Appendix 2: Pre-application response HBC 15th January 2016

Tel: 01895 250230
Case Officer: Karl Dafe
Email: kdafe@hillington.gov.uk
Date: 15th January 2016

**RE: Conversion of offices to residential. Conversion of nursing home to residential.
New Build lodge and associated landscaping and parking -total units 16**

SITE: Manor Farm High Street Harmondsworth

Elevation 2

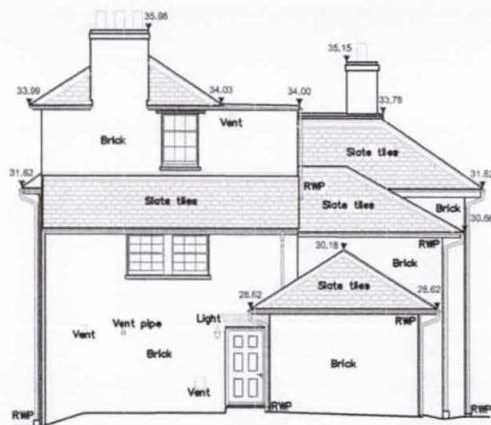
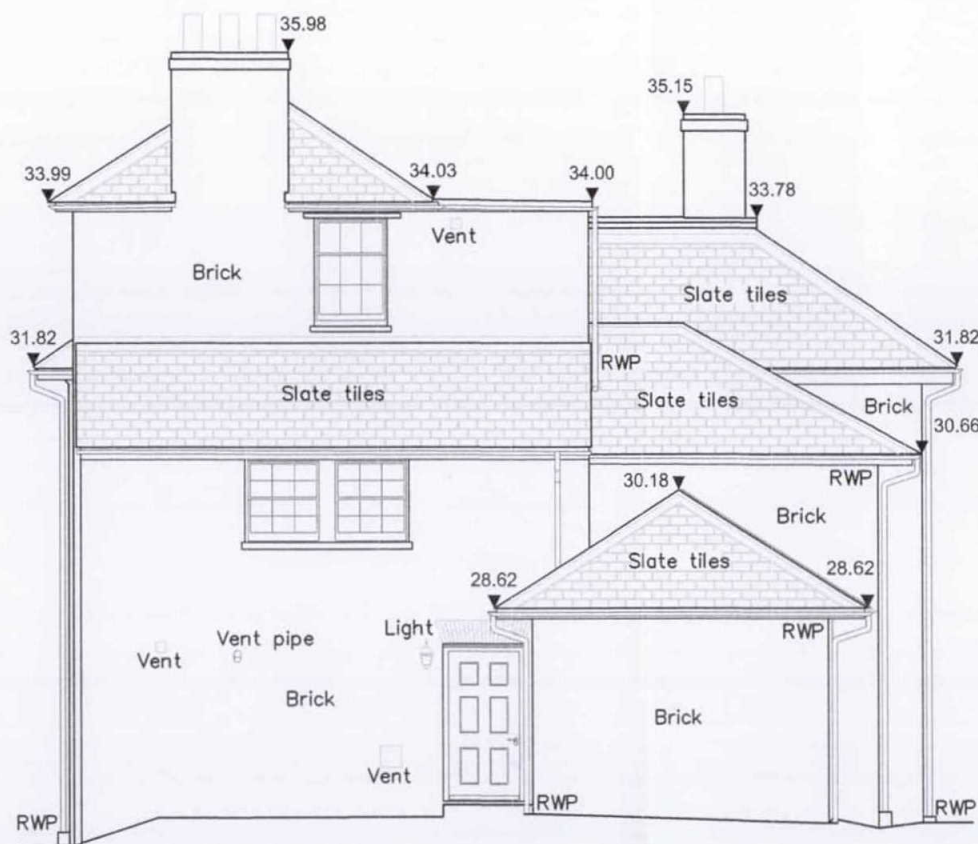
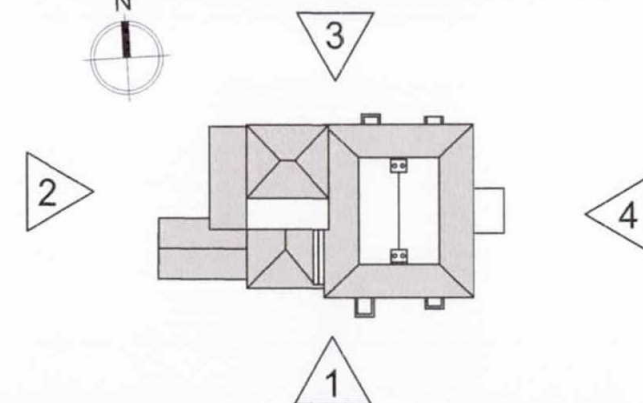
linked seamlessly with the existing structure. Ideally, the ridge line should be dropped on the first floor addition, to retain the step in scale that exists across elevation 1. The inserted windows to side elevation 3 are too large.

Elevation 4

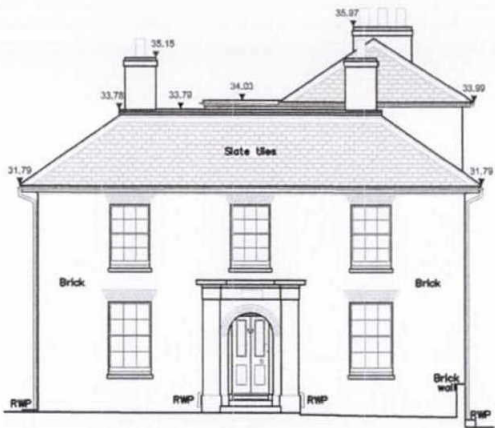
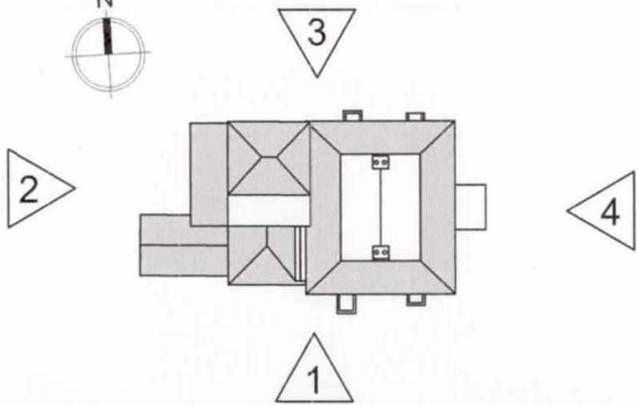
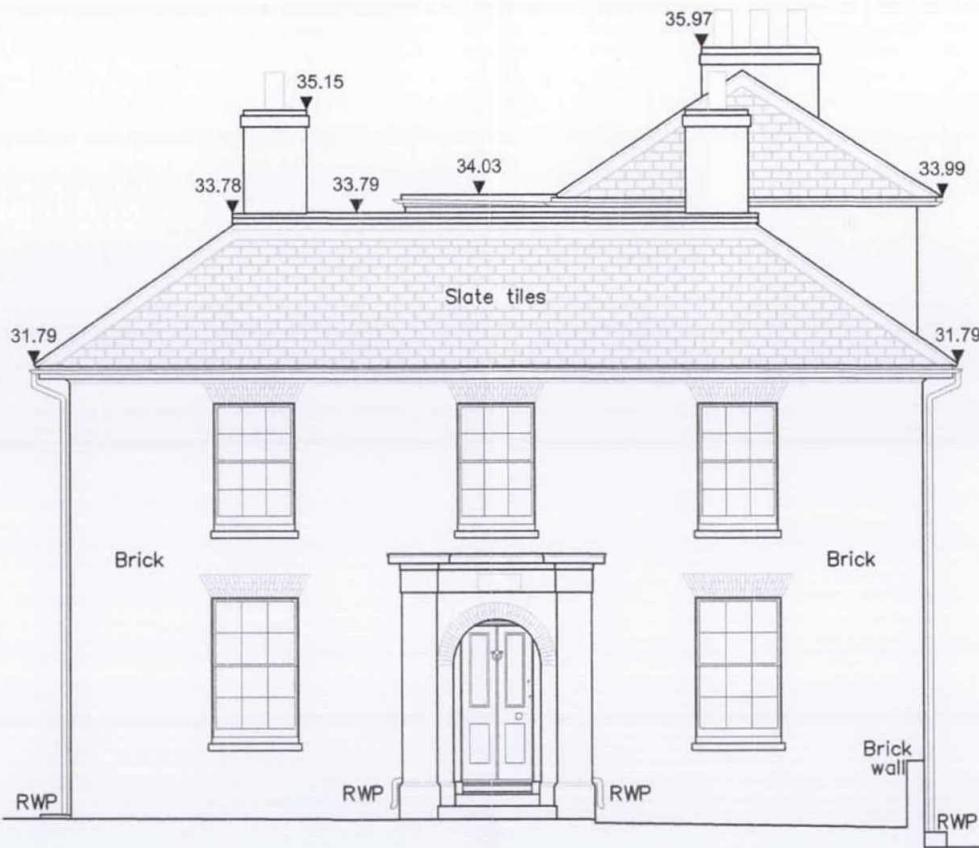
The glazed door on elevation 4 would be better designed as a traditional half stable door to avoid what looks like a hole in the elevation. There also appears to be an extra window at first floor front on the floor plans, which should be avoided.
